Table 1 – Department of Planning and Infrastructure

Table 2 – City of Sydney

SCALE @ B1 1:200	DRAWN AK	CO-ORD PS	REVIEWED PS	APPROVED CW
PROJECT NUMBER A004409	DRAWING NUMBER ARC-HSL-DA-SK001	REV A

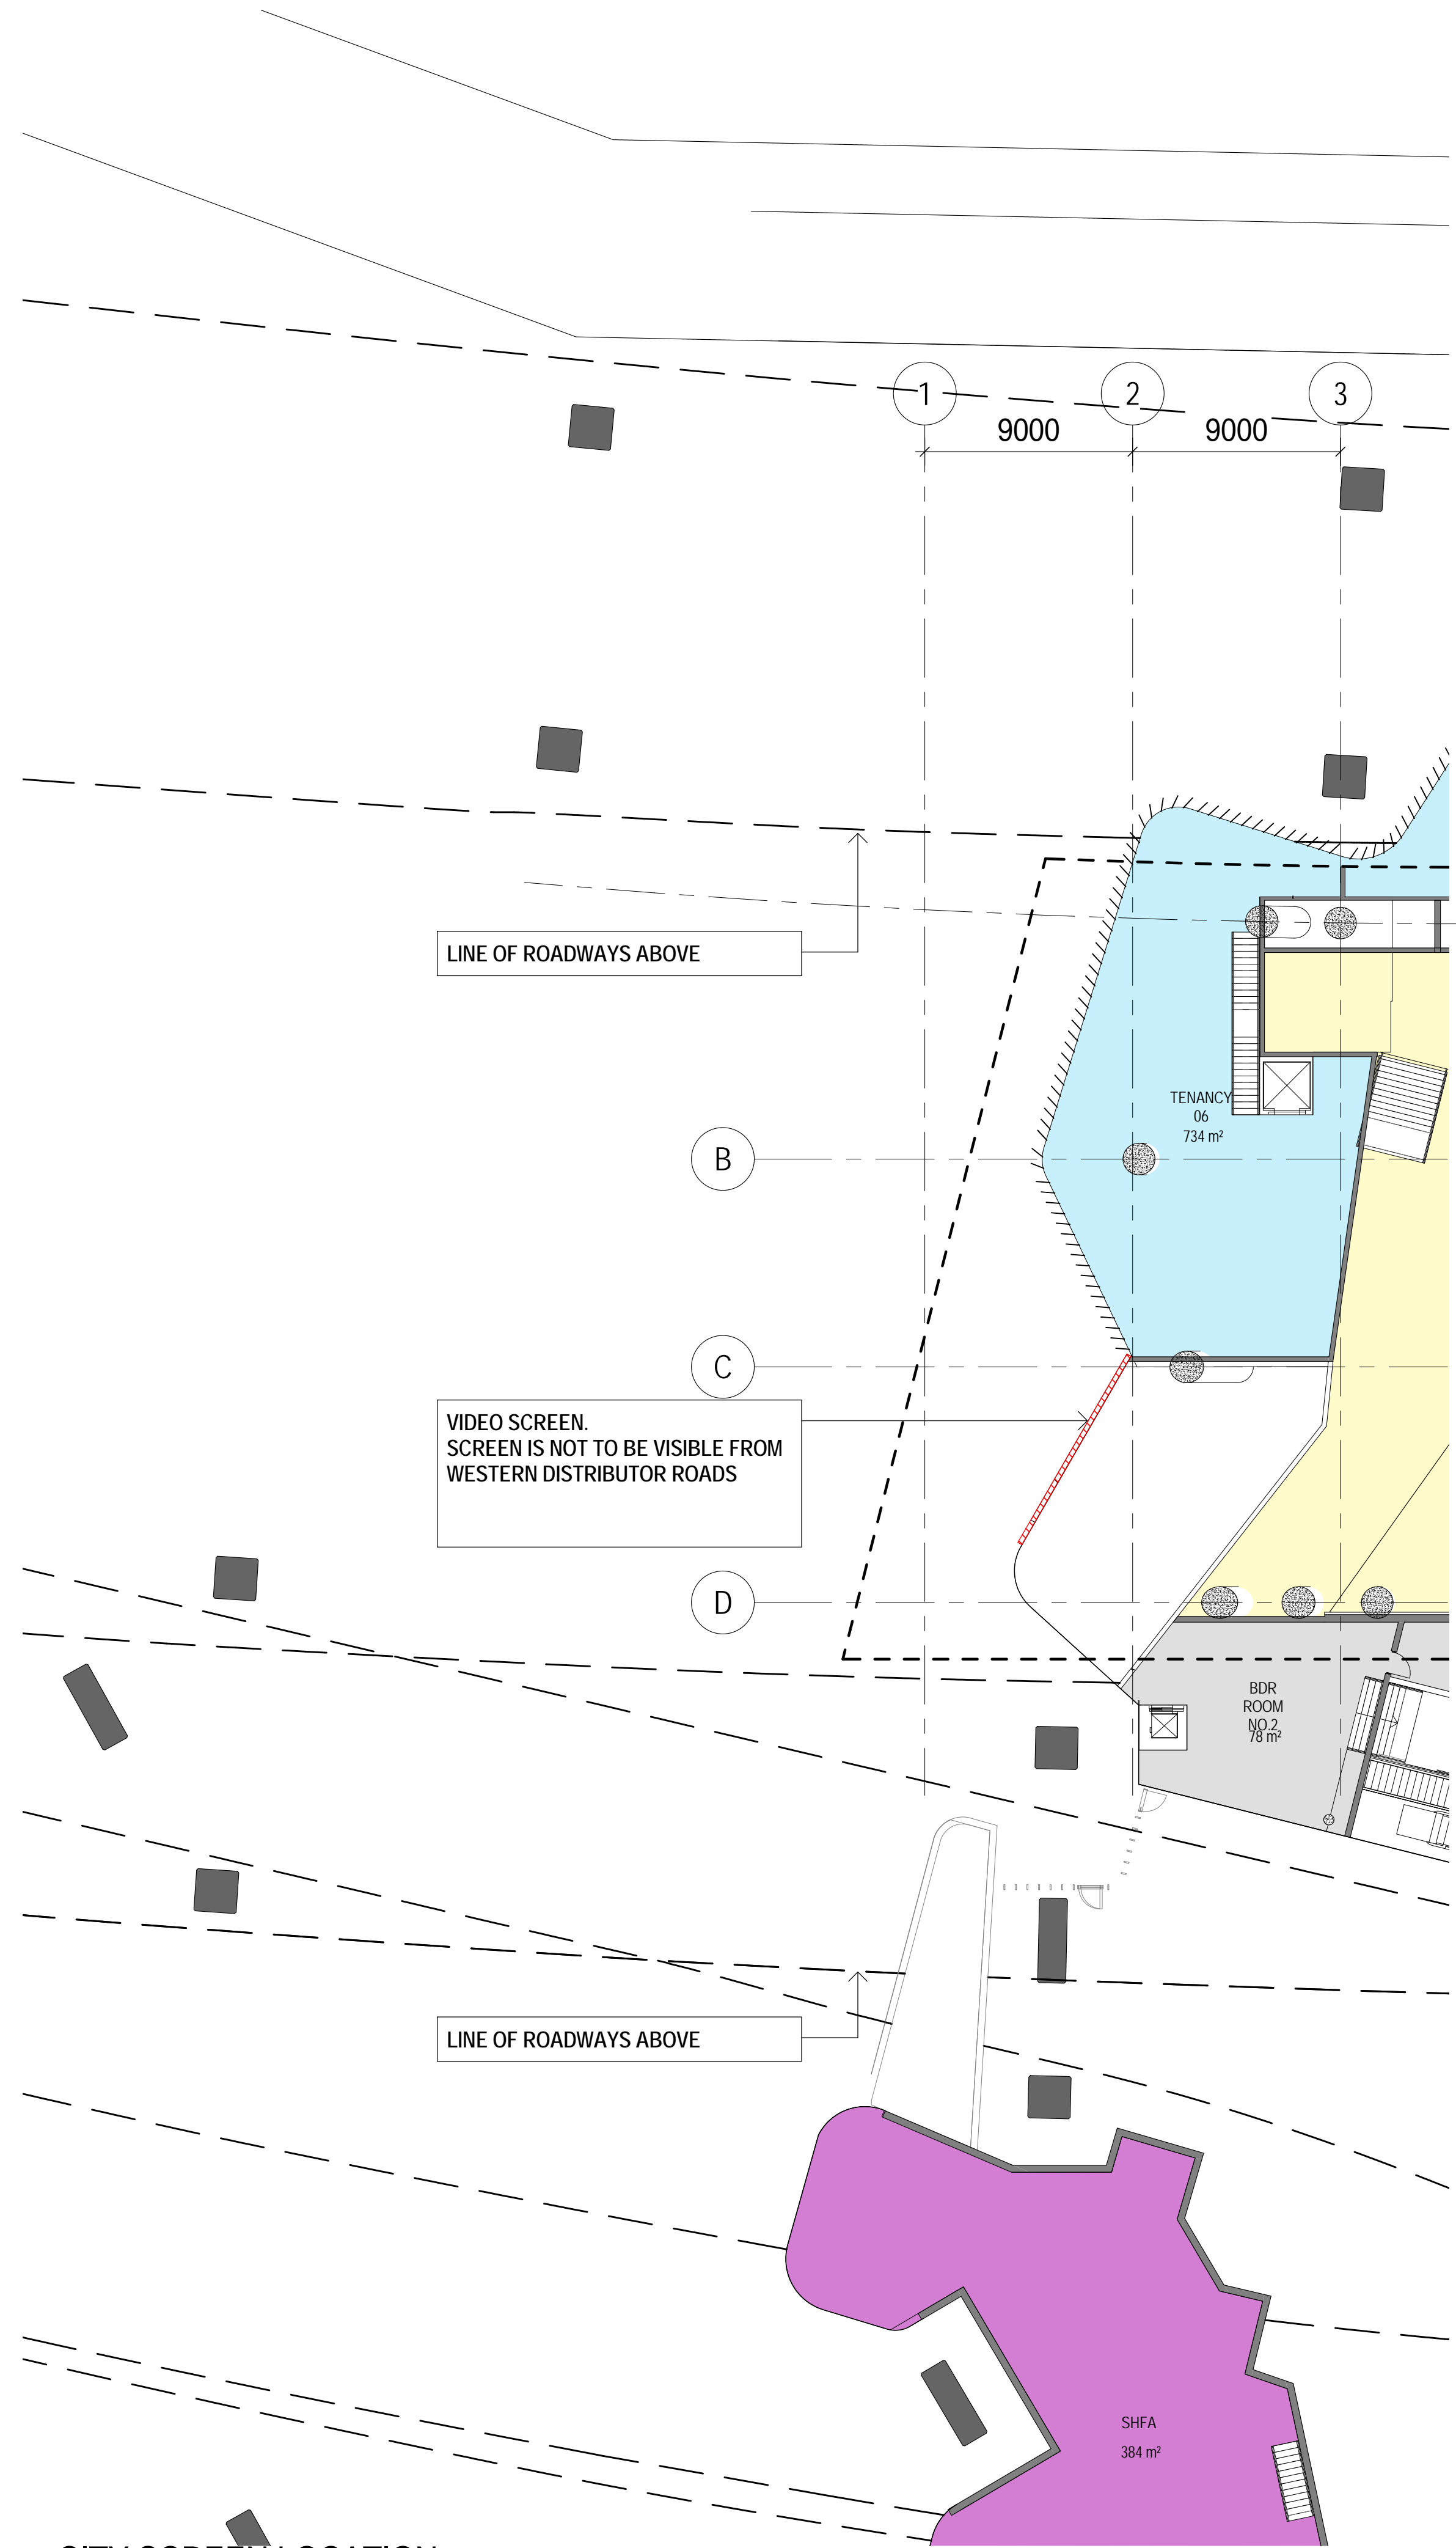
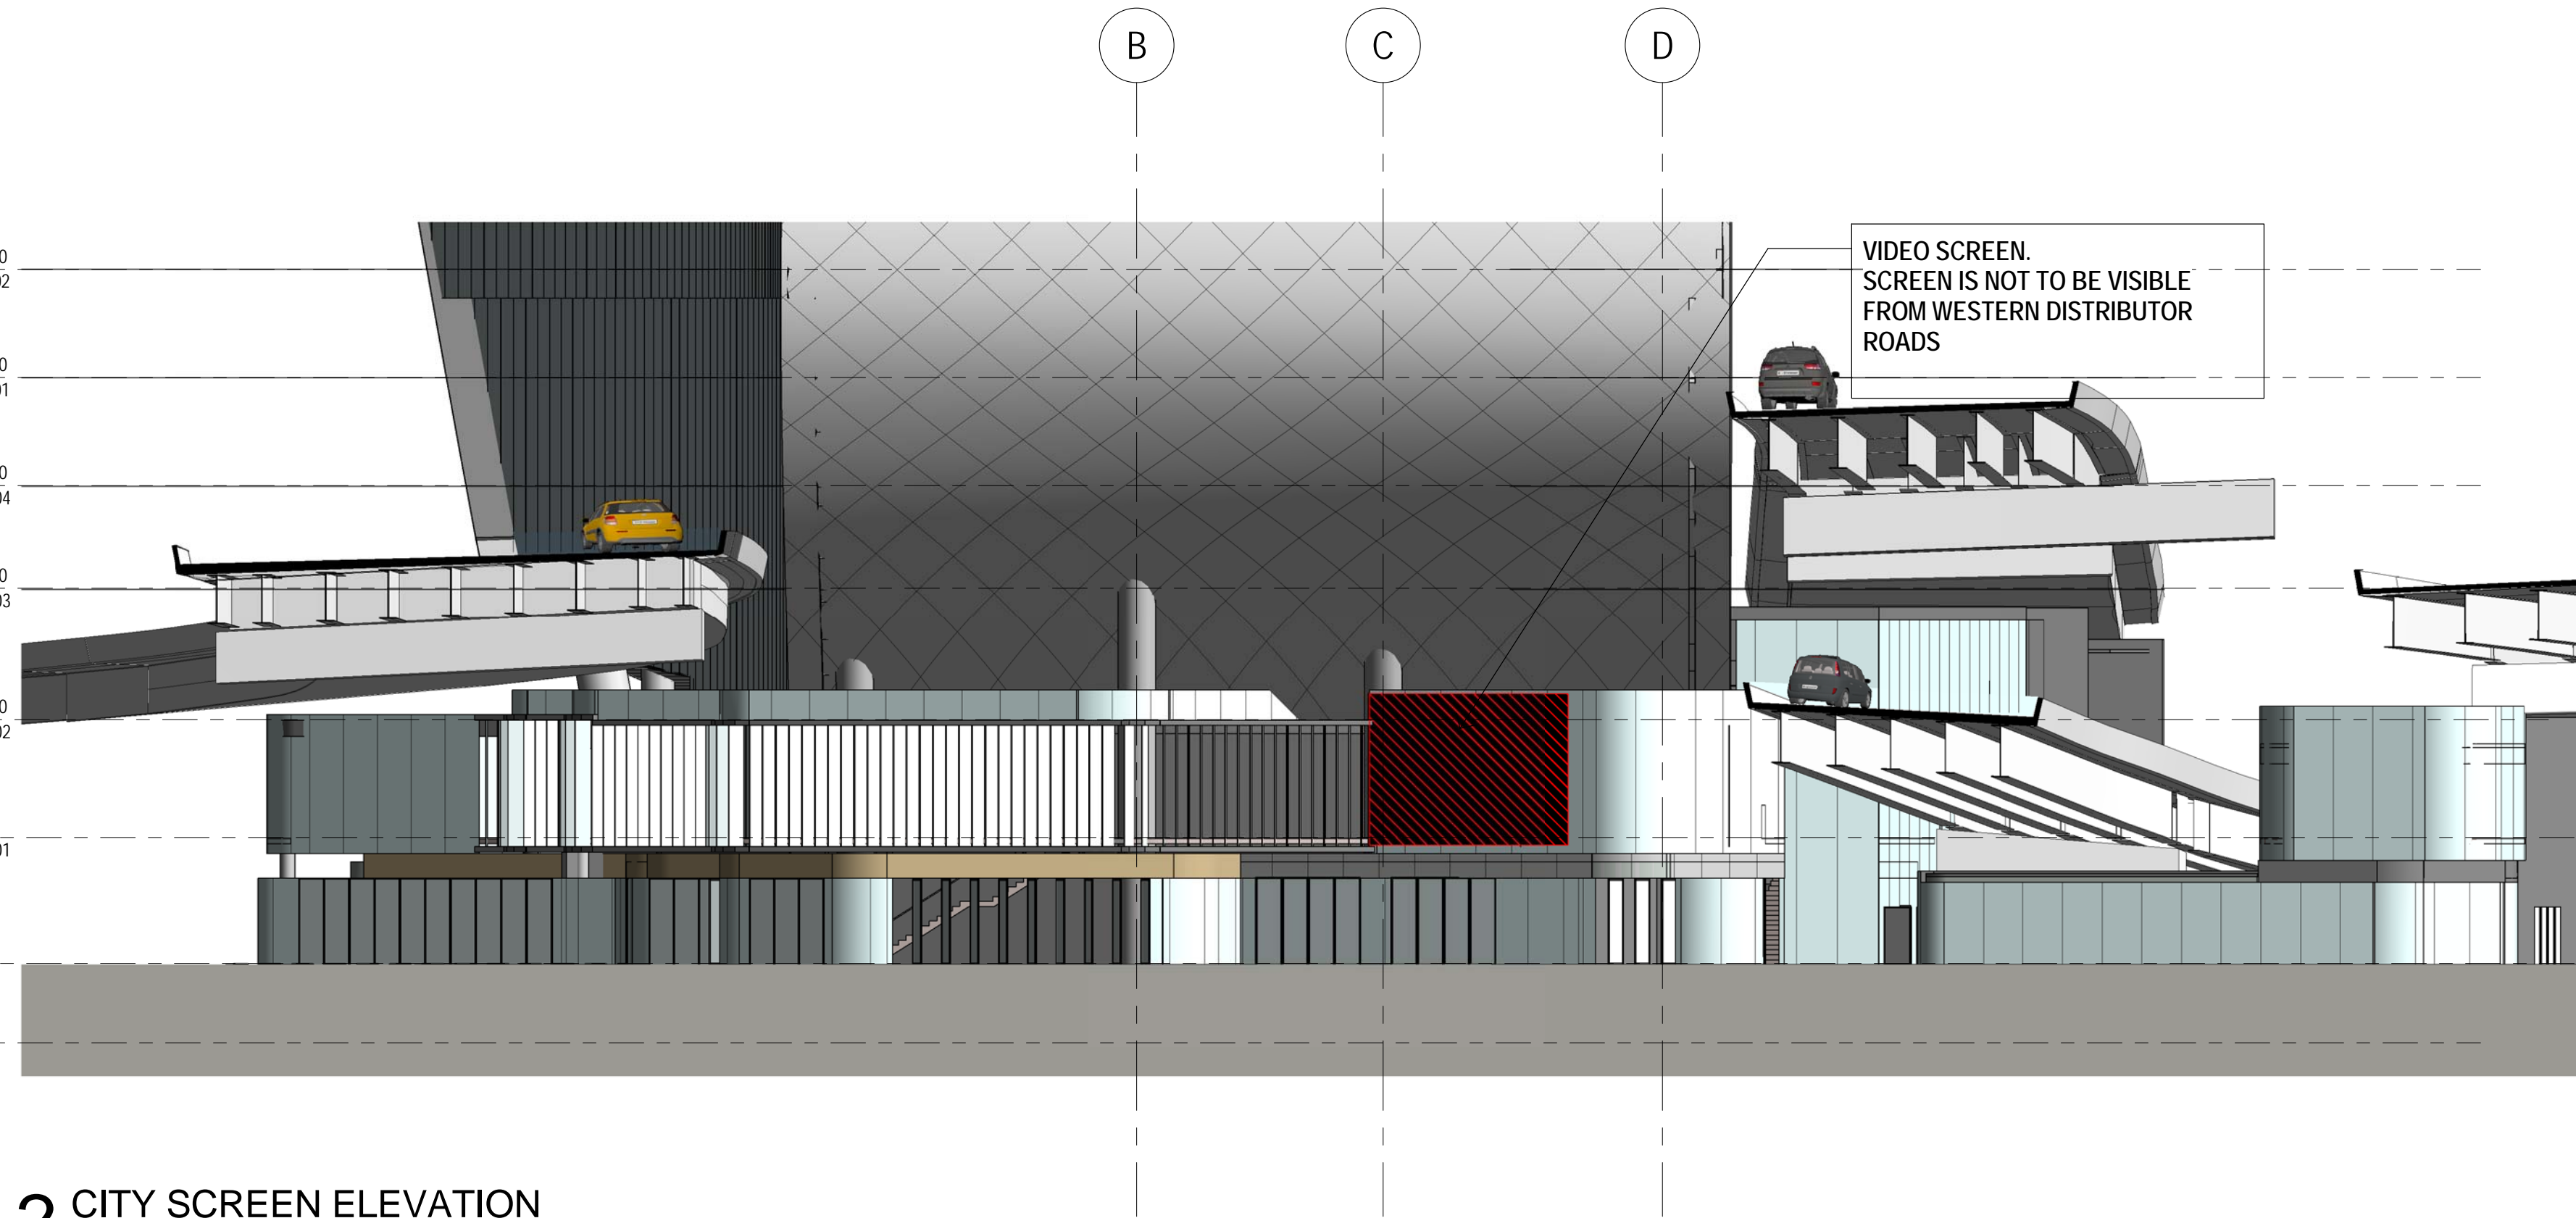
Architectural plans are to be submitted that identify the location and size of the City screen. Details are also to be provided which demonstrate that the City screen will not be able to be viewed from motorists on the Western Distributor (as indicated in the EIS).	Additional drawing SK001 (refer Appendix B) details the size and location of the City Screen. The screen will not be visible from the western distributor.
Heritage	Further analysis is to be provided on the impact of the proposal on the heritage significance of Pyrmont Bridge as outlined in the NSW Heritage Council correspondence.	Refer Section 2.5.2 of Response to Submissions.
